Arun District Council
Arun Civic Centre
Maltravers Road
Littlehampton
West Sussex BN17 5LF
Planning & Building Control General Enquiries
Tel: (01903) 737756 Fax: (01903) 730442
Dx: 57406 Littlehampton
Minicom: 01903 732765
e-mail: planning@arun.gov.uk
website: www.arun.gov.uk/planning

Application No: AW/151/20/PL
Site Address: 17 Nyewood Lane Aldwick PO21 2QB
Description of works: Change of use of former residential parenting unit (C2 Residential Institution) to 9 bed House in Multiple Occupation (Sui Generis).

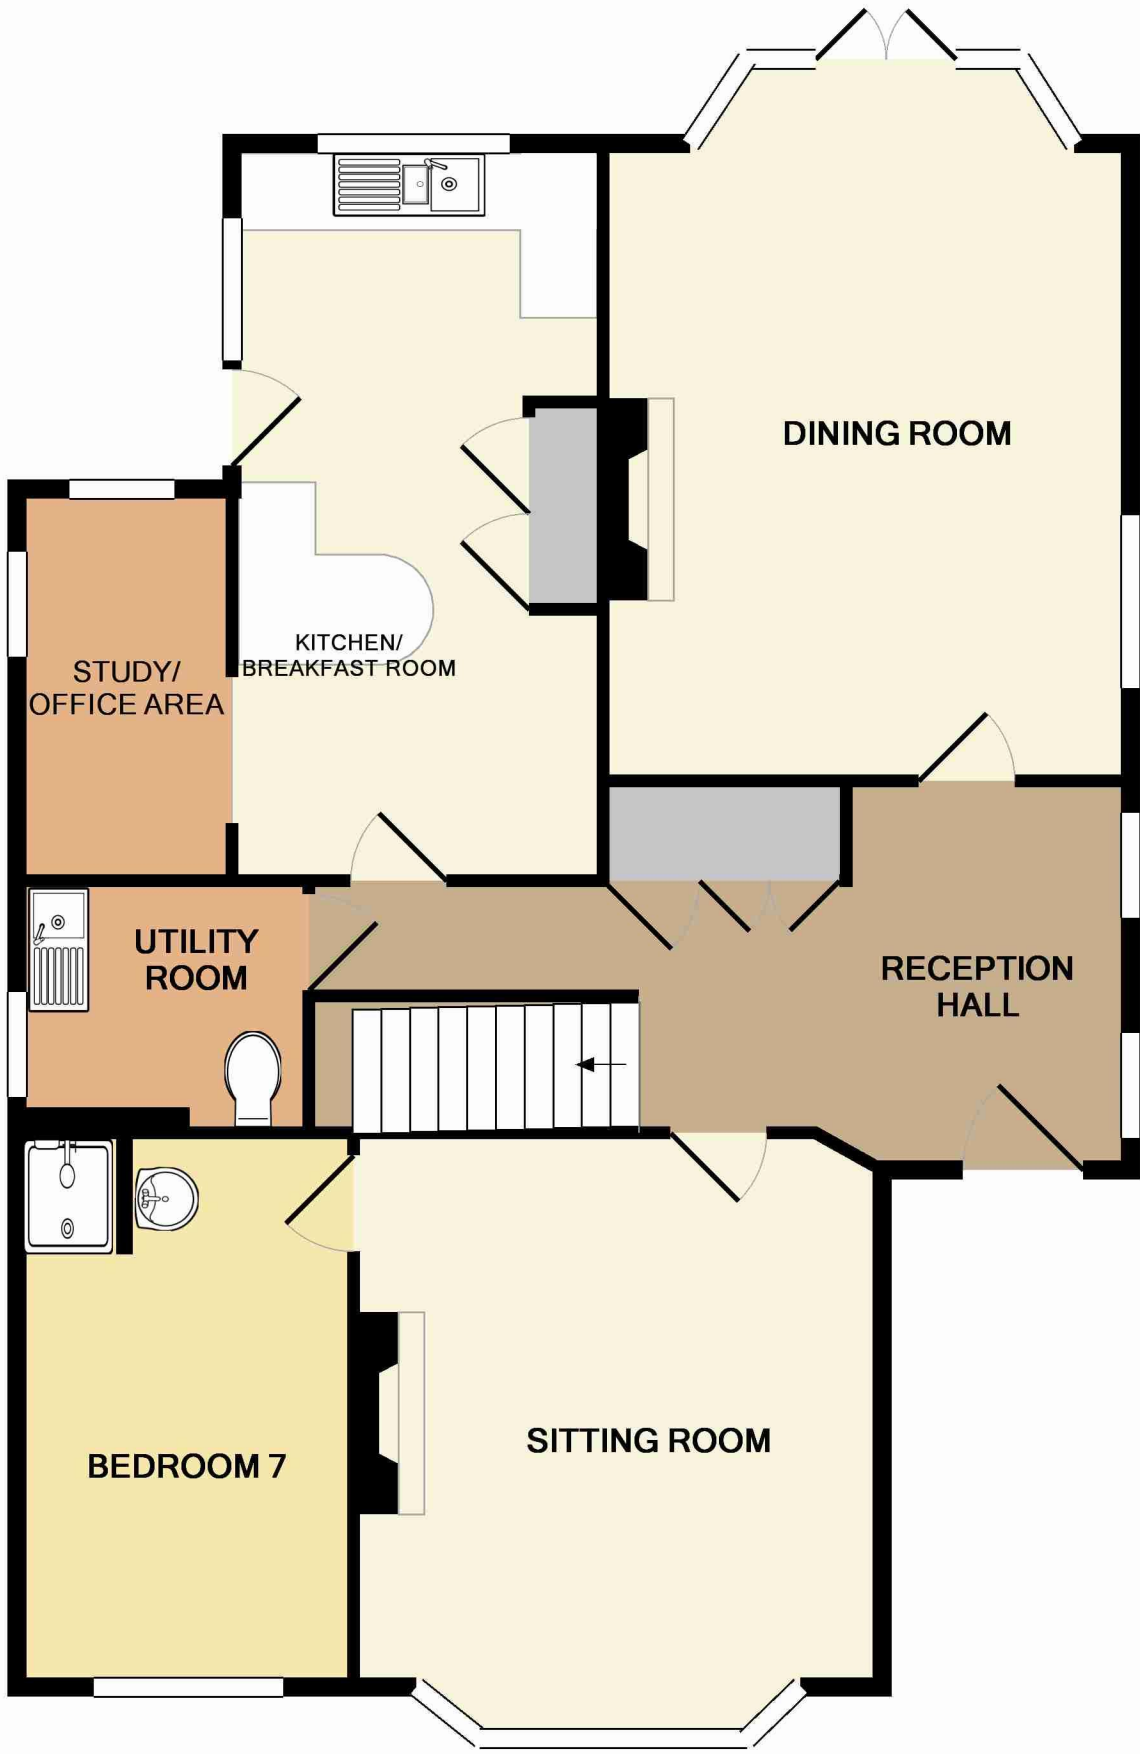
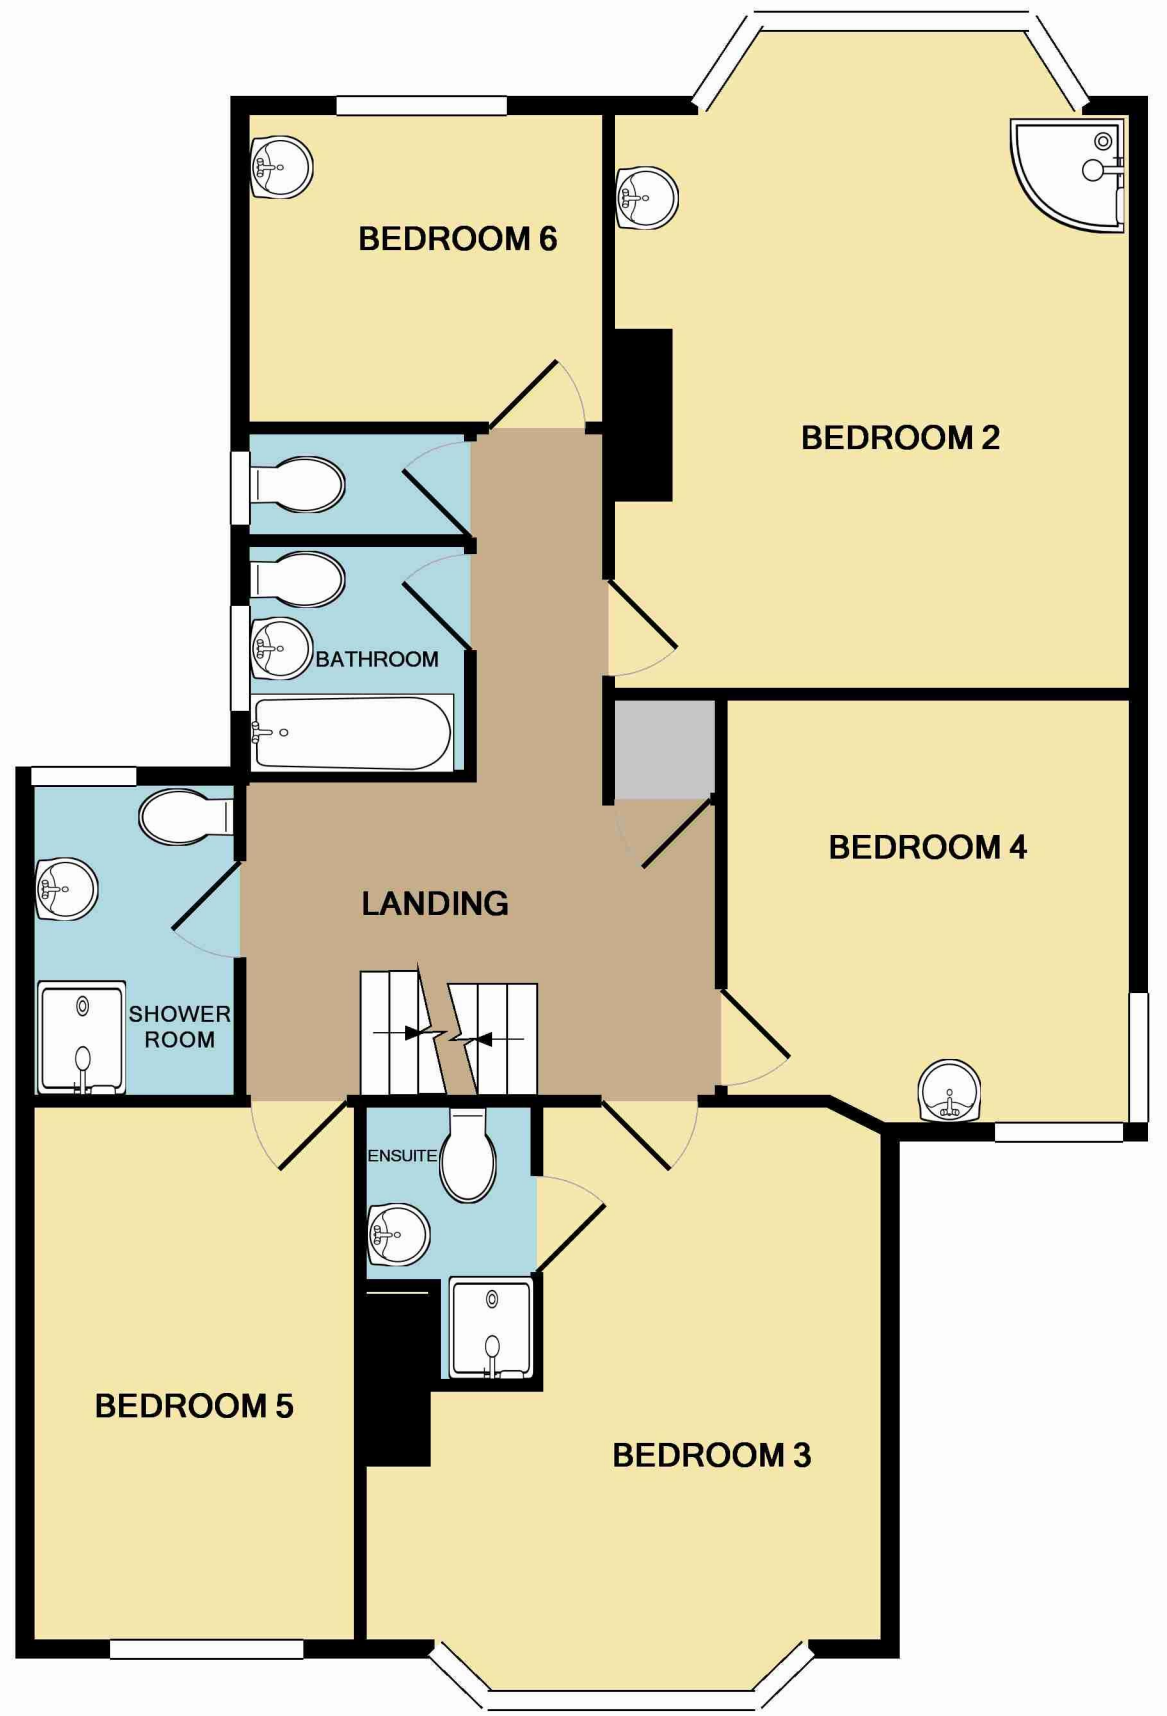
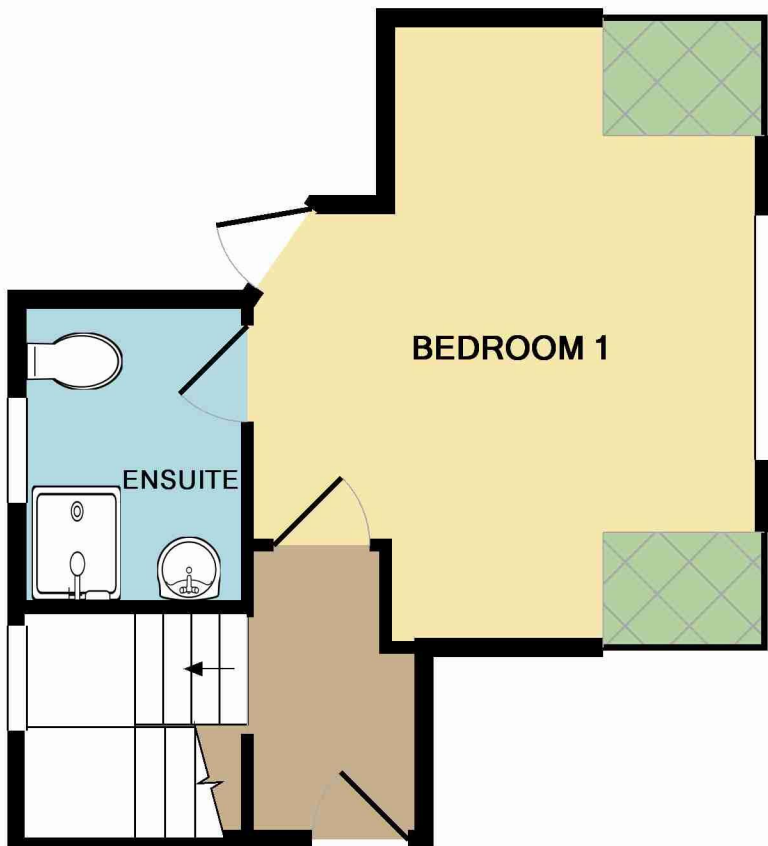
Members strongly objected to the proposed application, noting that Plans provided are those provided previously in 2017 for a 7 bedded residential home since when (October 2018), laws regarding room sizes and safety measures have undergone changes and which are summarised in a letter from the Private Sector Housing and Public Health Department of Arun District Council. The Planning Committee is also aware that planning for the previous development which used the same footprint and plans was granted prior to the adoption of the Arun Local Plan 2011 - 2031 and that this proposal adds a further 2 rooms to the original plan.
